From: Matthew Driver [REDACTED]
Sent: 17 August 2017 09:04
To: Michael Eastham
Cc: Ian Carey
Subject: RE: BN/28/17/RES - The Lillies, Barnham Road

Arun District Council's Drainage Engineer has highlighted the fact that the proposed development layout does not satisfy condition no.9, imposed on the outline permission, in respect to maintaining access to the existing watercourse.

JOB NO.	DRAWING NO.	REV
MATT151202	SL.01	P5

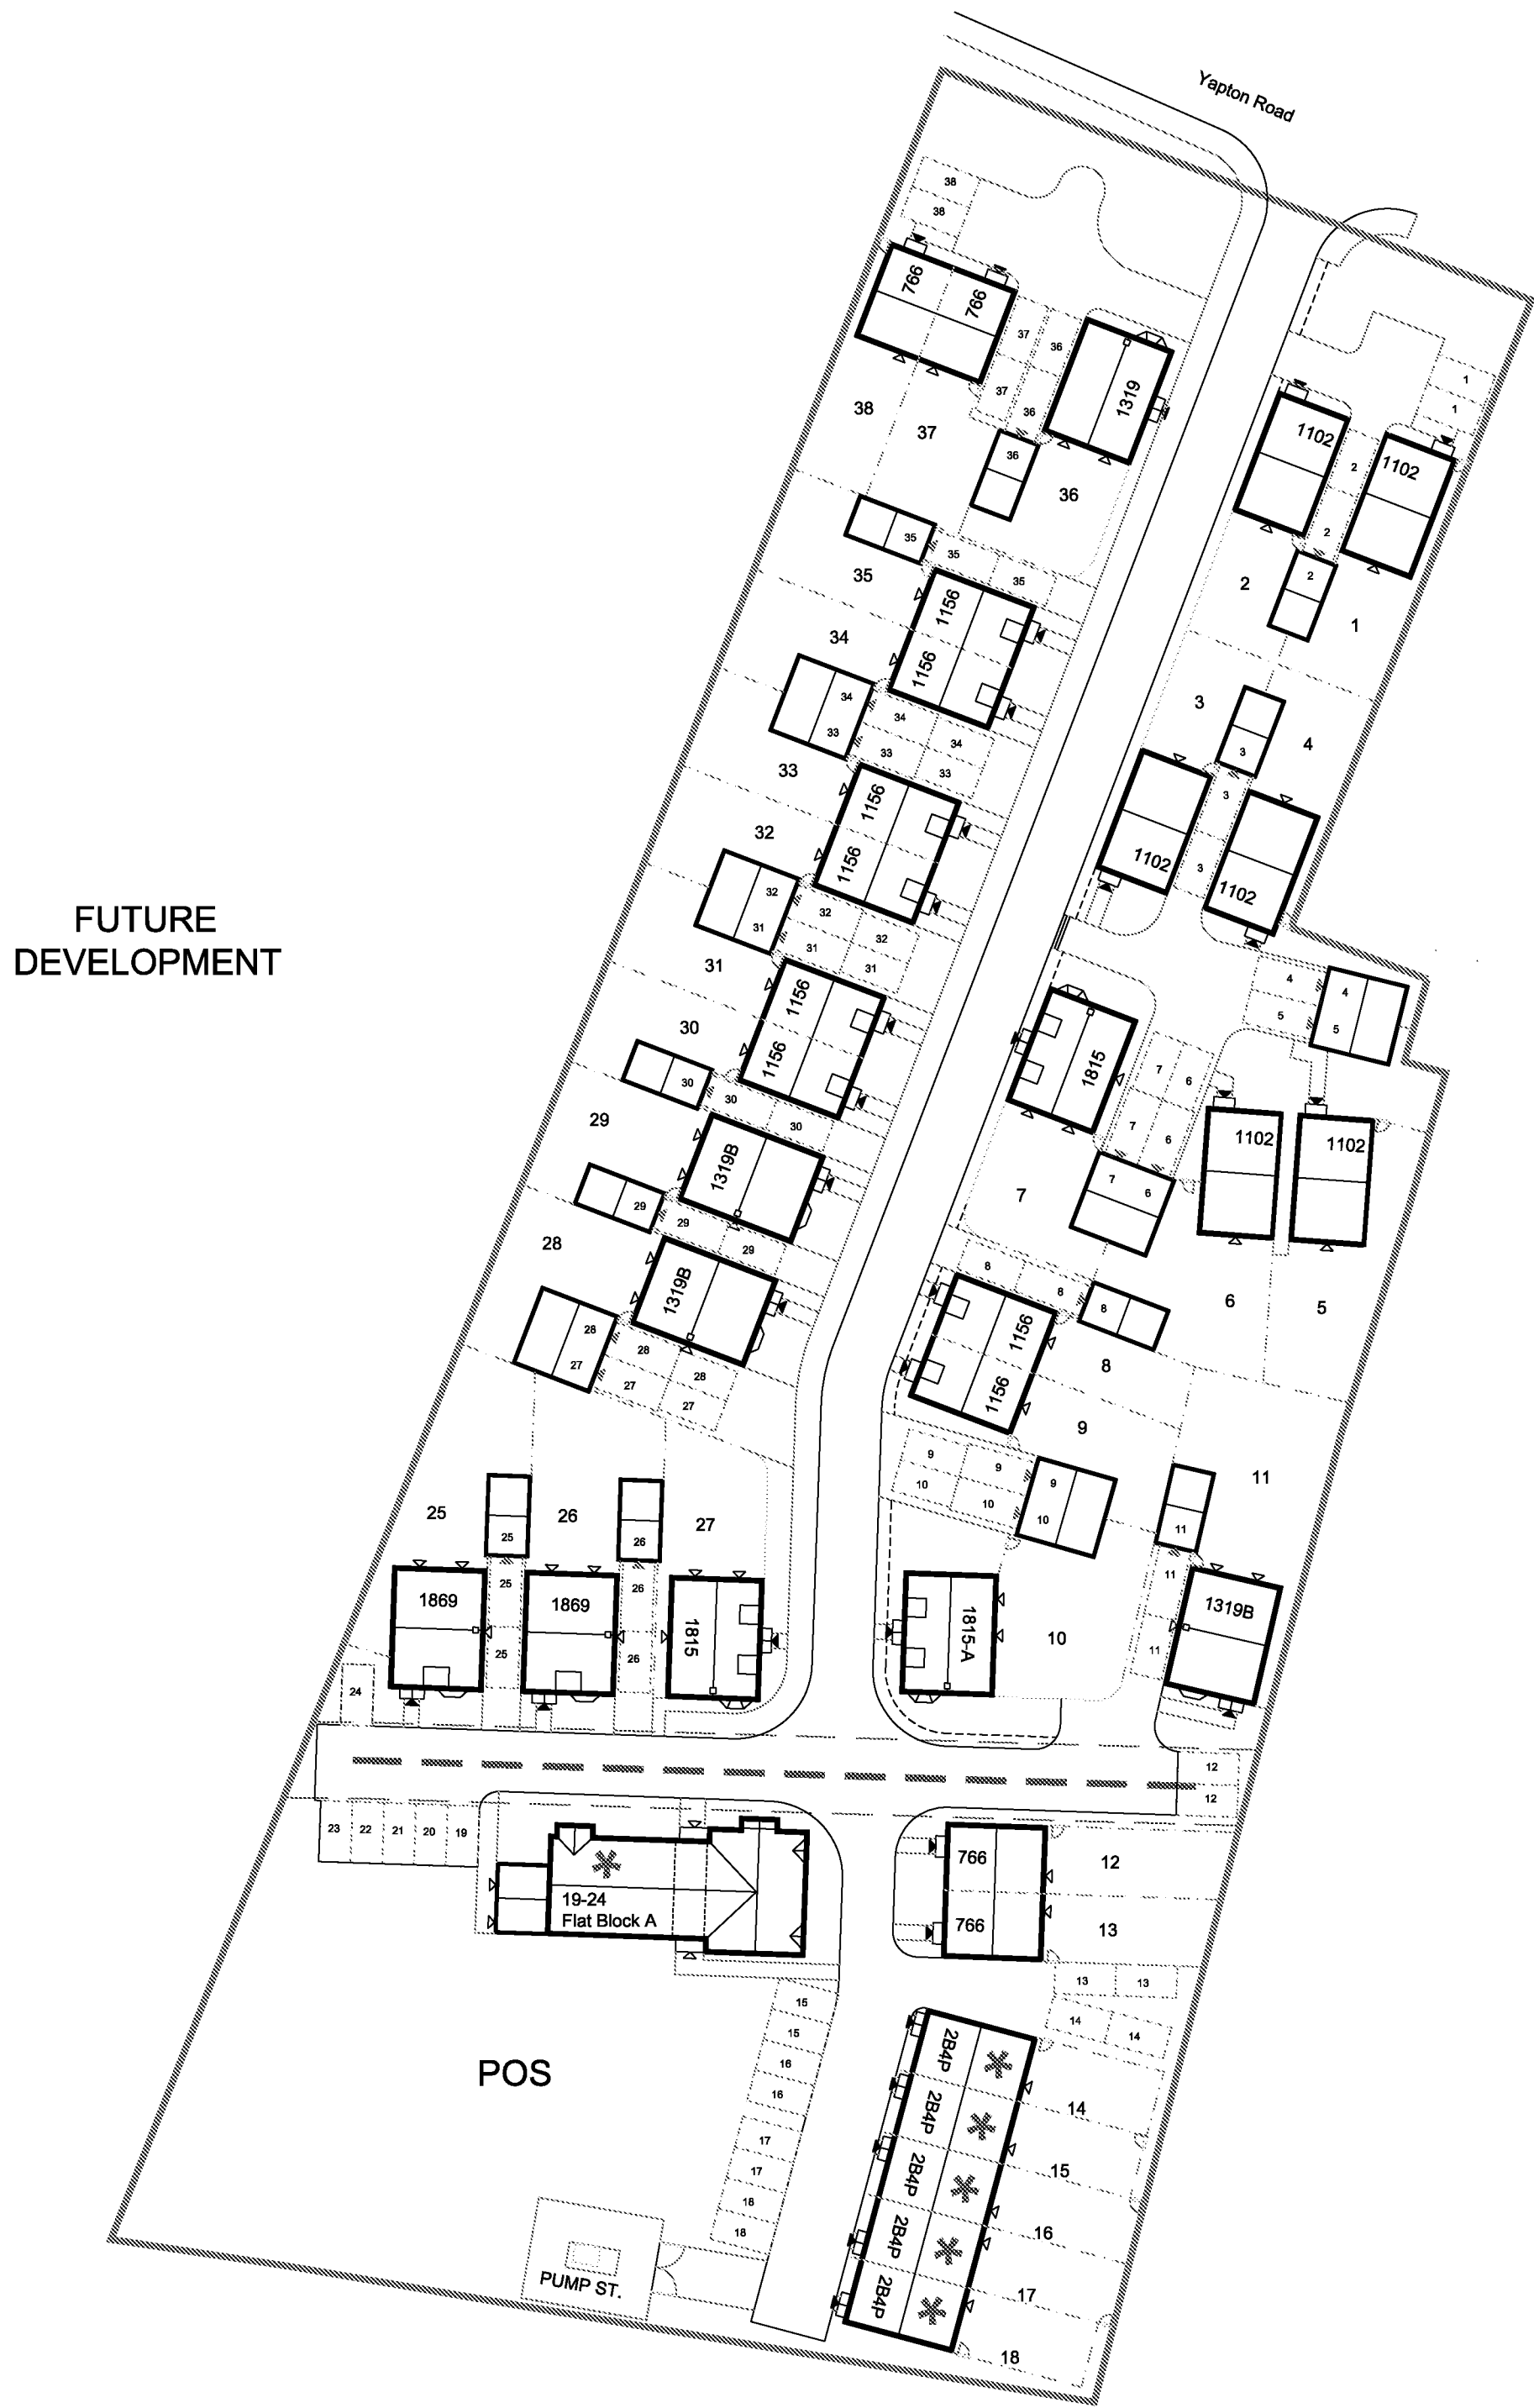
A three metre wide easement strip is required from the top of the bank and to be free of all obstructions including boundary fences. The foul water pumping station compound and one of the dwellings conflicts with this requirement. – From what I can see in the conditions there is no specified distance re 3m off-set.

APPENDIX D

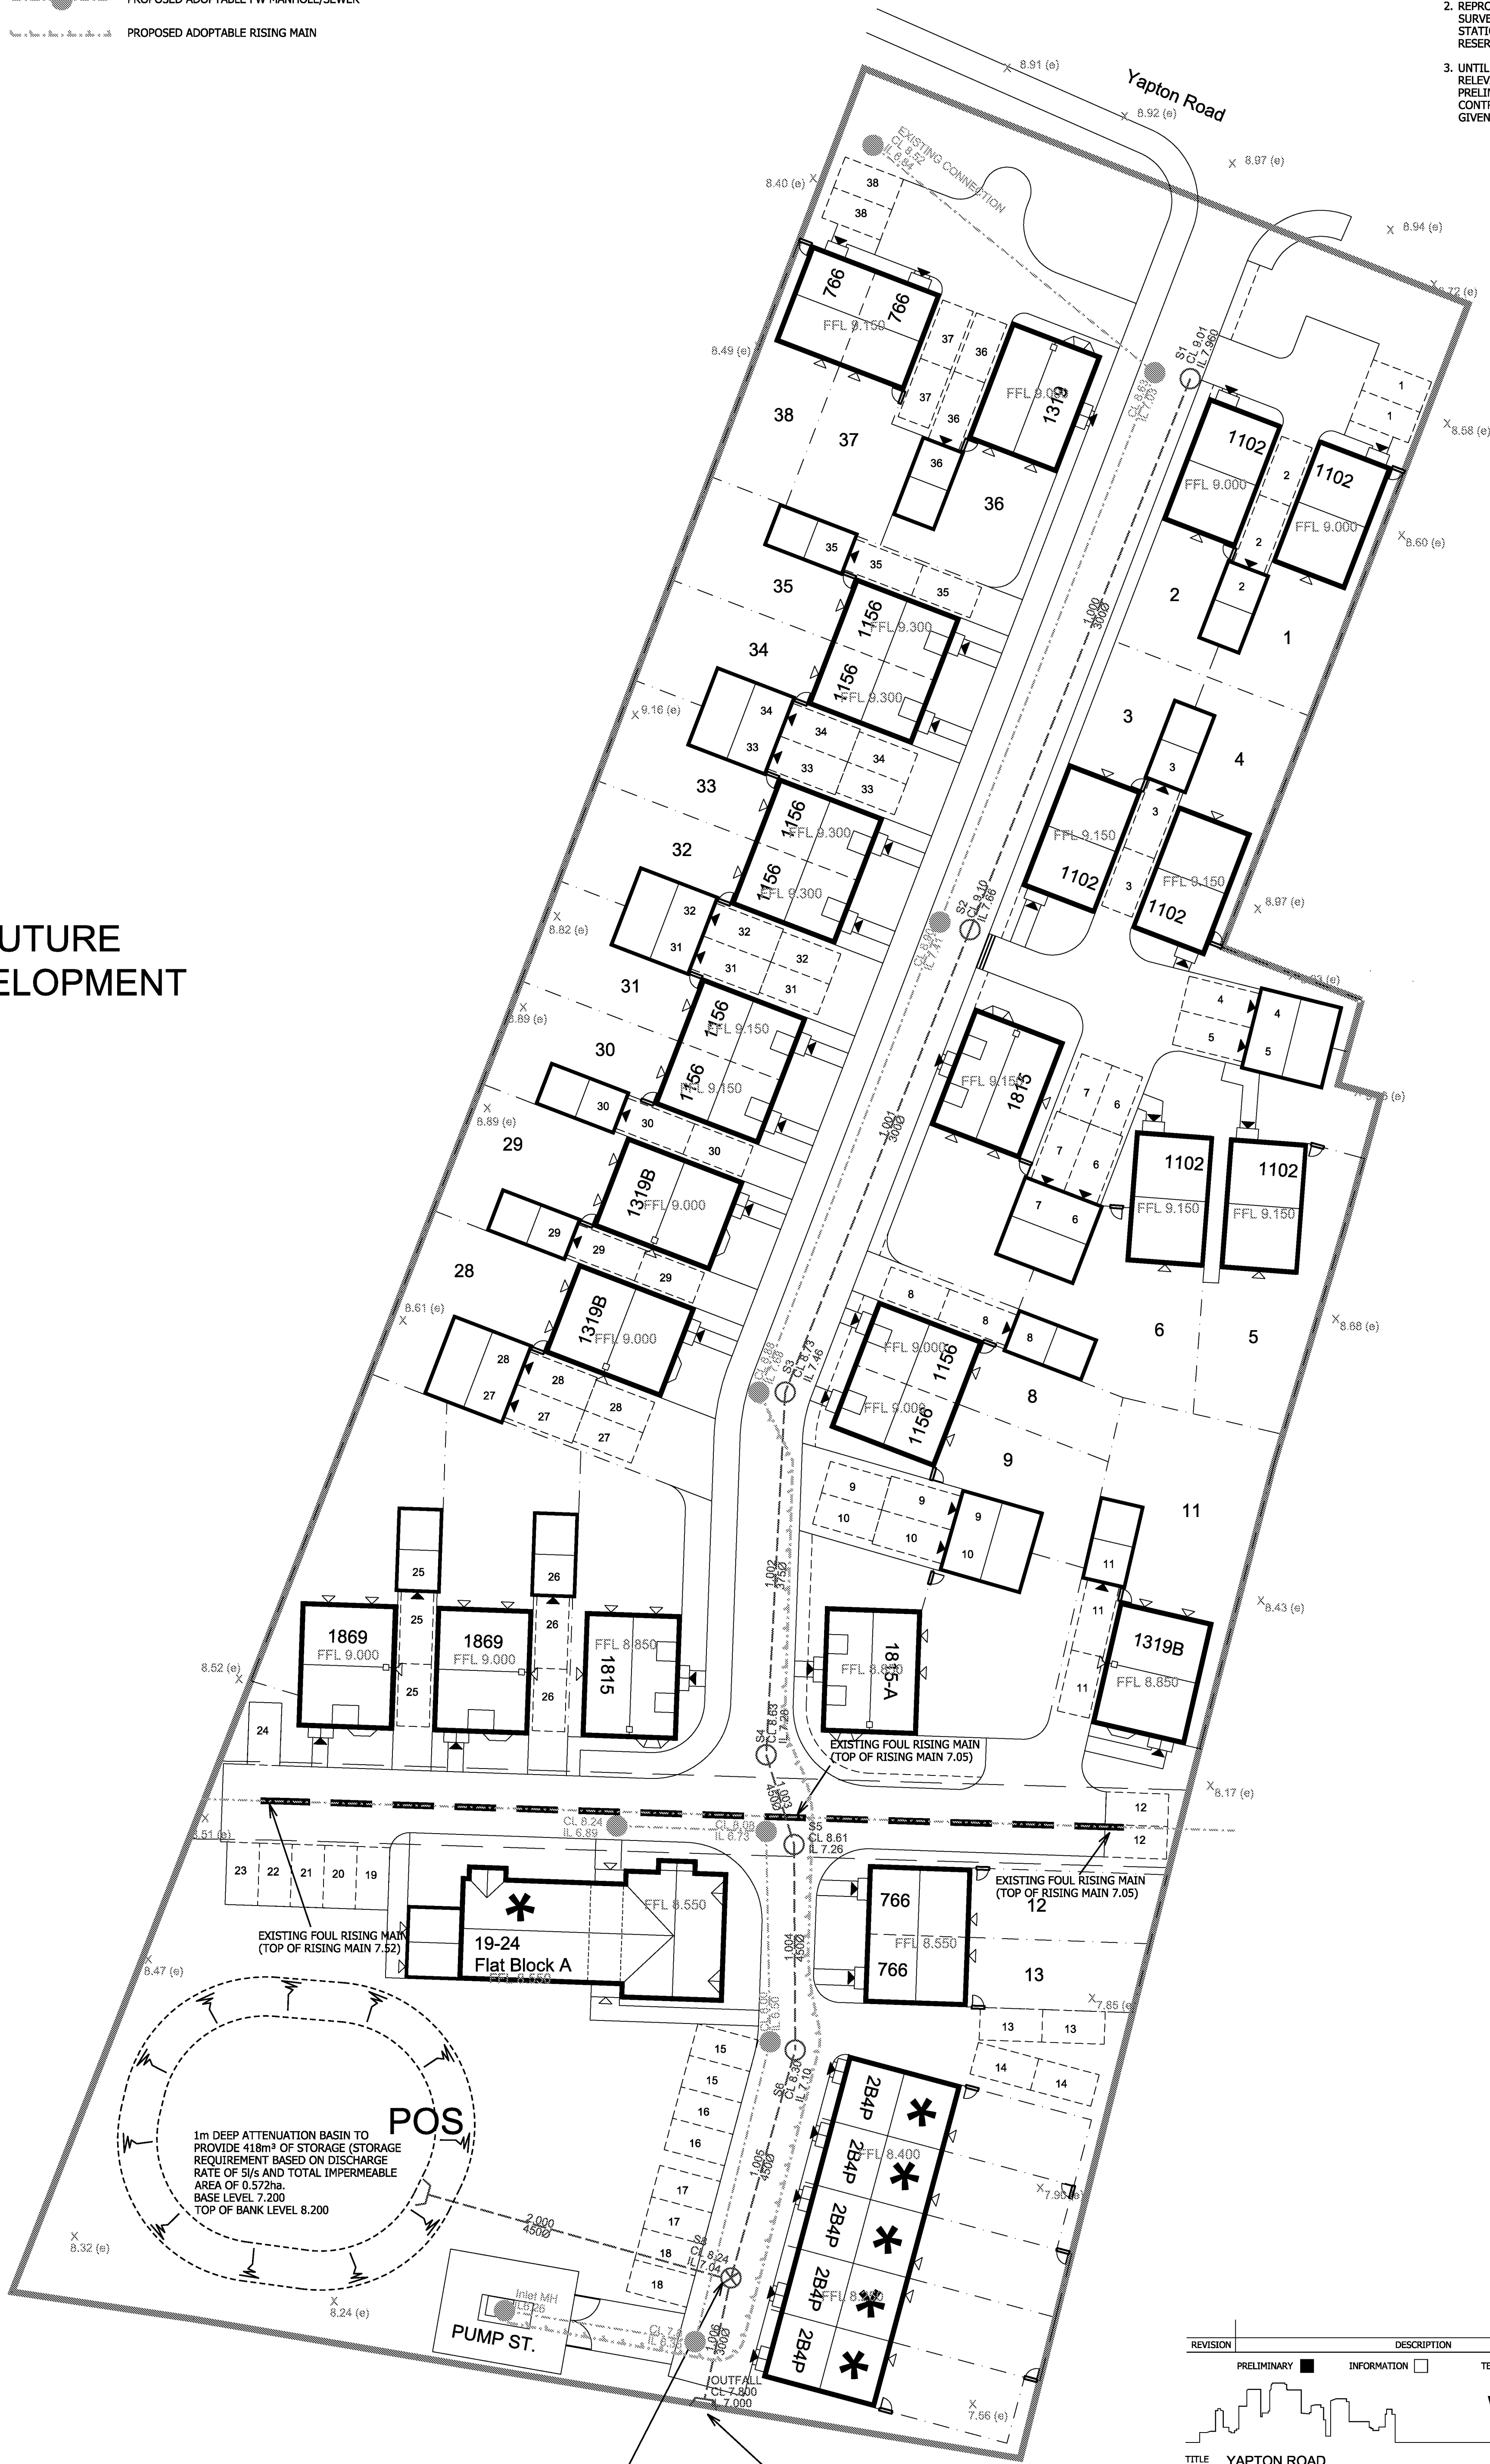
The principle of the surface water drainage scheme is acceptable, however, its detailed design will need to be agreed. This will include hydraulic calculations to confirm the sizing of the pond, construction details of the pond (taking into account potentially high groundwater levels/floataction), full details of the remainder of the surface water drainage system, improvements to the existing watercourse, etc. - calculations were provided as part of the FRA-C attached

The applicant should also investigate the use of permeable paving where possible (with impermeable liners to combat the high water table) in order to provide a degree of water treatment/flow attenuation. - This will be looked at during detailed design but a vegetated pond will provide many of the same benefits without the issues of conveyance of areas of permeable paving.
